**Interim Submission**  
**Pending resolution of issues associated with access to the**  
**Bay and Basin Leisure Centre precinct**

**SHOALHAVEN CITY COUNCIL**  
**ENVIRONMENTAL ASSESSMENT SUBMISSION TO THE NSW DEPARTMENT**  
**OF PLANNING**  
**PART 3A, ENVIRONMENTAL PLANNING & ASSESSMENT ACT, 1979**

**MAJOR PROJECT APPLICATION MP 06\_0205**  
**Modification No 2**

**PROPOSAL:** Proposed MP06\_0205 VDC Stage 1 - Modification No 2 being modification to the VDC Stage 1 approval by delivery of the VDC is two stages with Stage 1 now being approx 22,600m<sup>2</sup> and the future Stage 2, being approx 9400m<sup>2</sup> floor area, and associated arrangements; and the delivery of various off-site works before occupation of the VDC Stage 1.

MASTER CONCEPT PLAN
SCALE: 1:1000 @ A1, 1:2000 @ A3

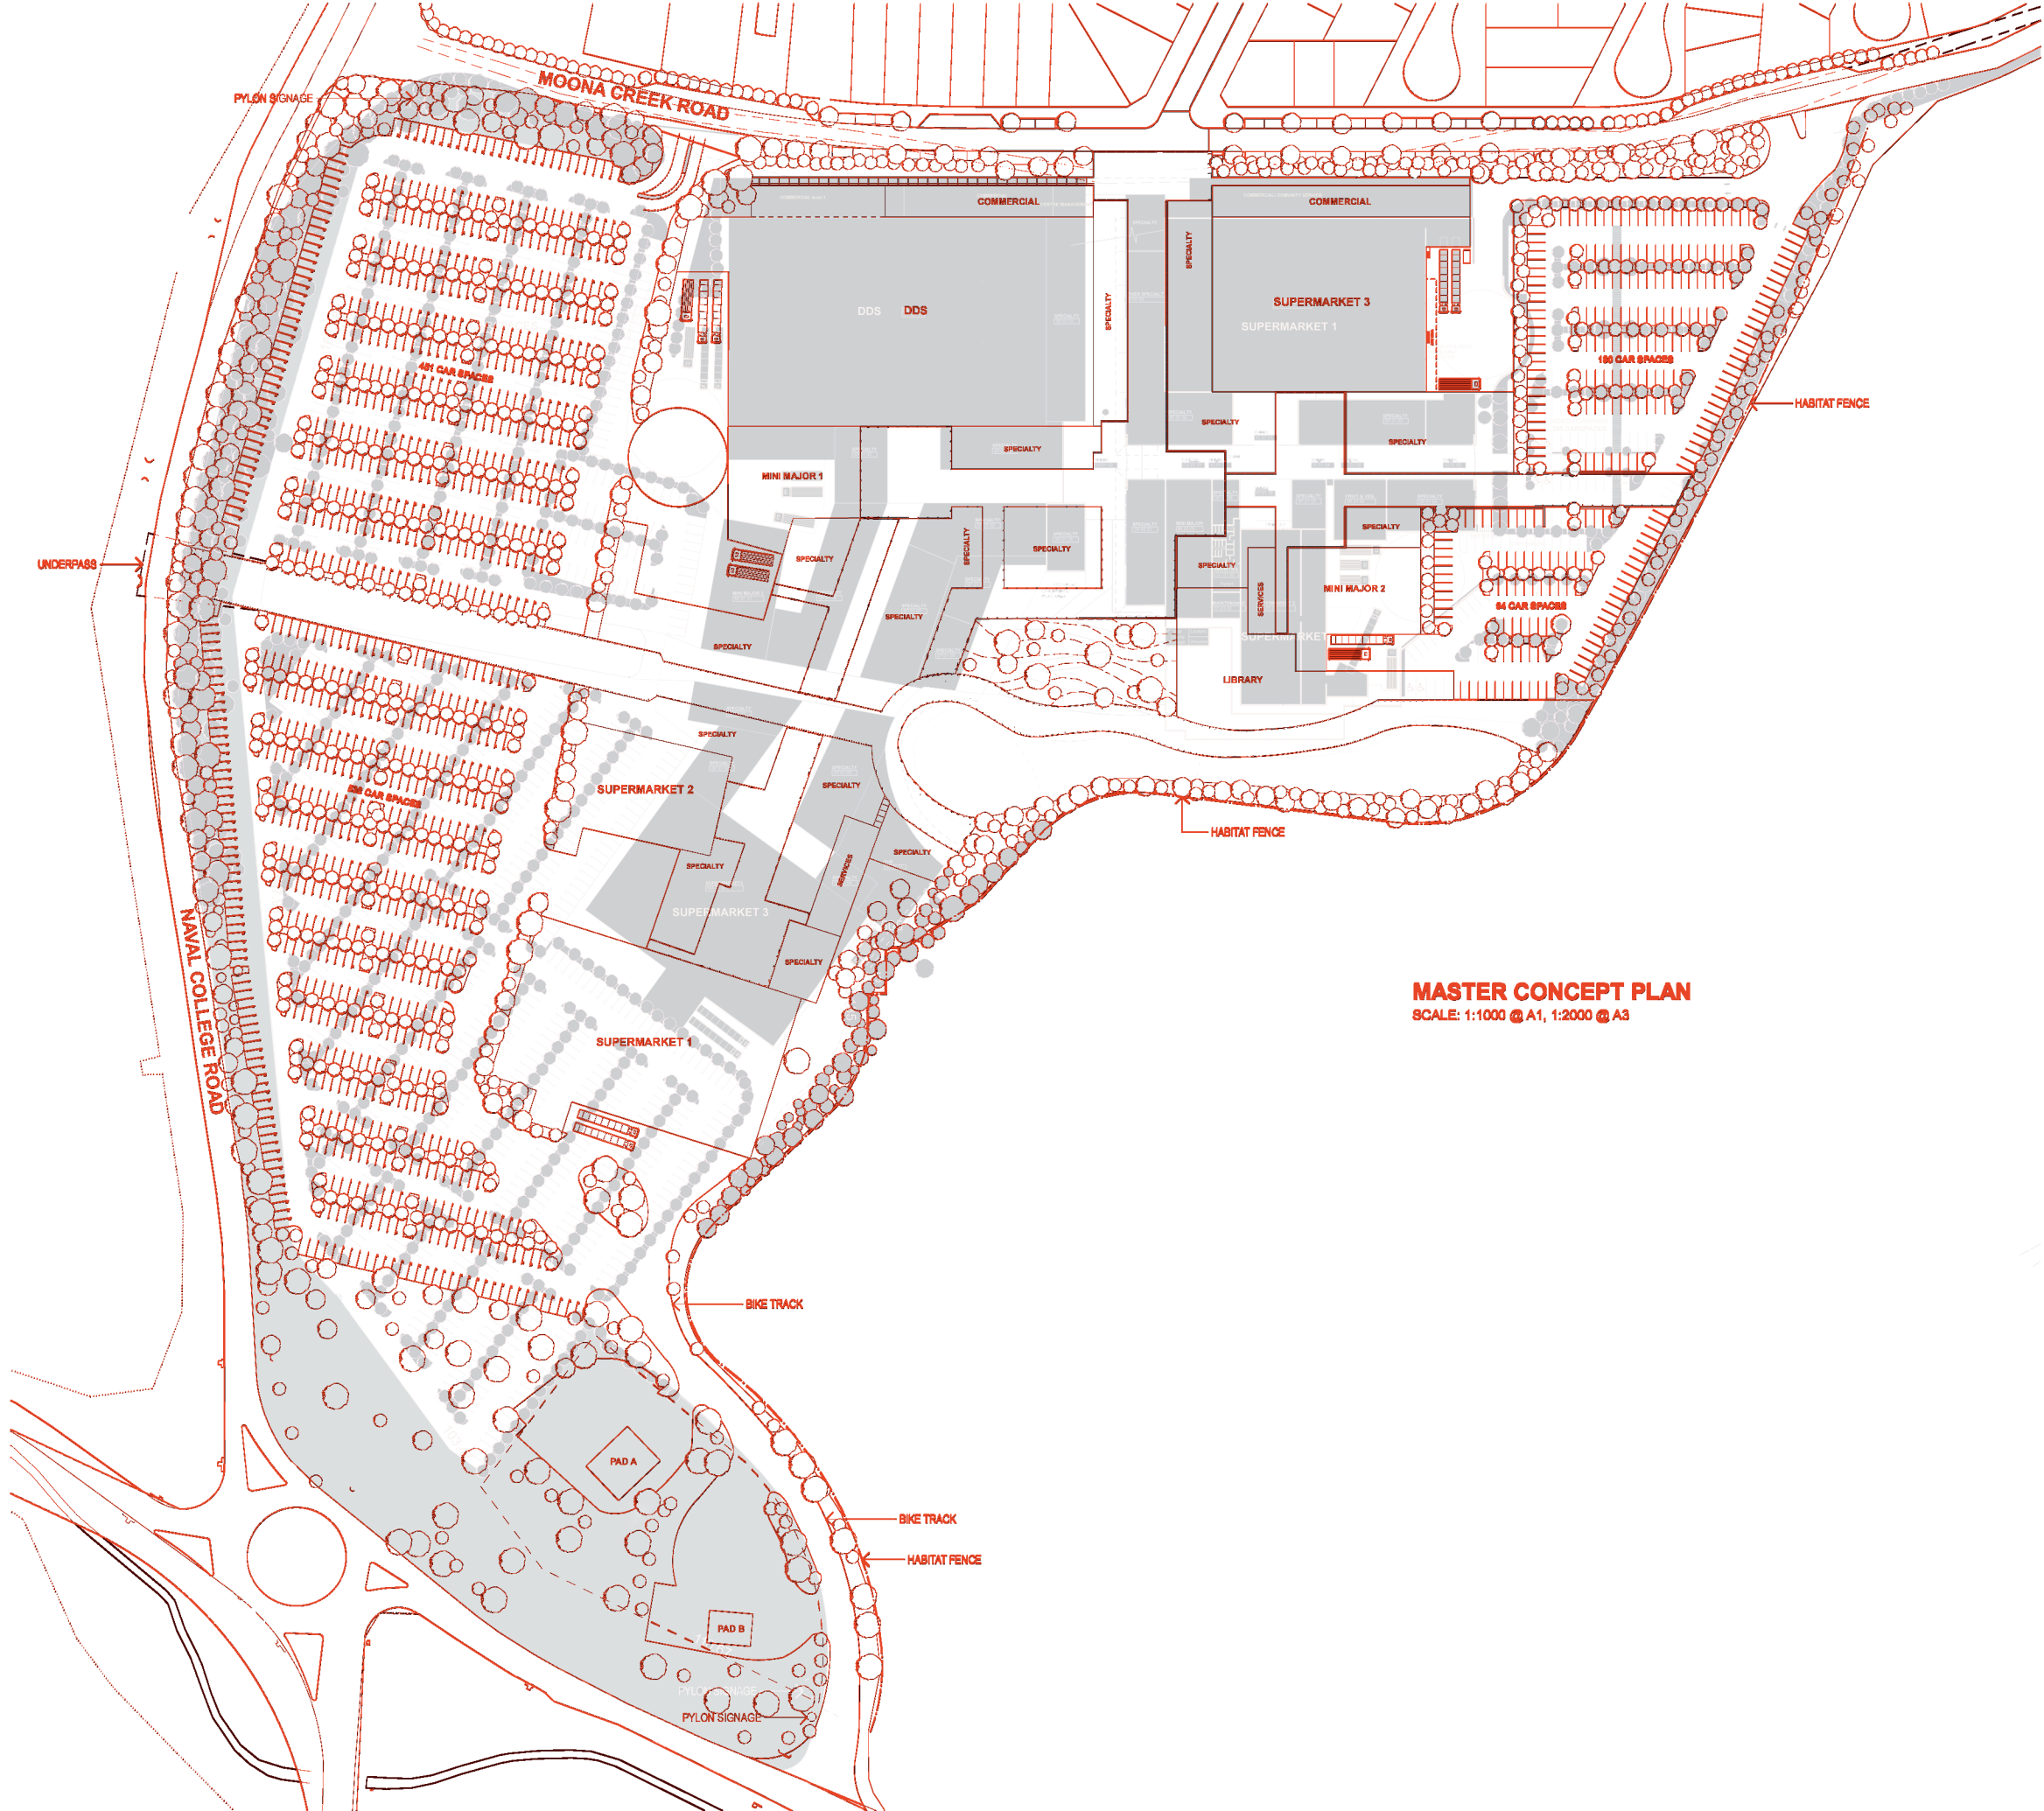
The layout on the Rice Daubney plan DA0103 shows the central east-west boardwalk through the south car park. The Cardno layout / boardwalk plan 46701 shows a different layout where the parking spaces are located differently. To protect the integrity of the drainage system under the boardwalk, the Rice Daubney layout at this part of the layout is preferred.

Council considers this is short-sighted in that the drawing DA0103 does not represent the statement in cl 2.24. The need for long vehicle parking should not be underestimated and should be provided as a permanent facility in Stage 1. The expected Stage 1 occupation is planned to coincide with the busy pre- Christmas trade and a peak holiday period. As such, there will be potentially maximum car parking demand at the outset. At the time when Stage 2 construction commences shopping patterns by residents and holiday visitors will be settled and permanent long vehicle parking should be determined at the earliest stage, suitably signposted and with appropriate manoeuvring and access arrangements. The current layout including separation bio-swales and landscaping does not currently enable the required provisions to be implemented.
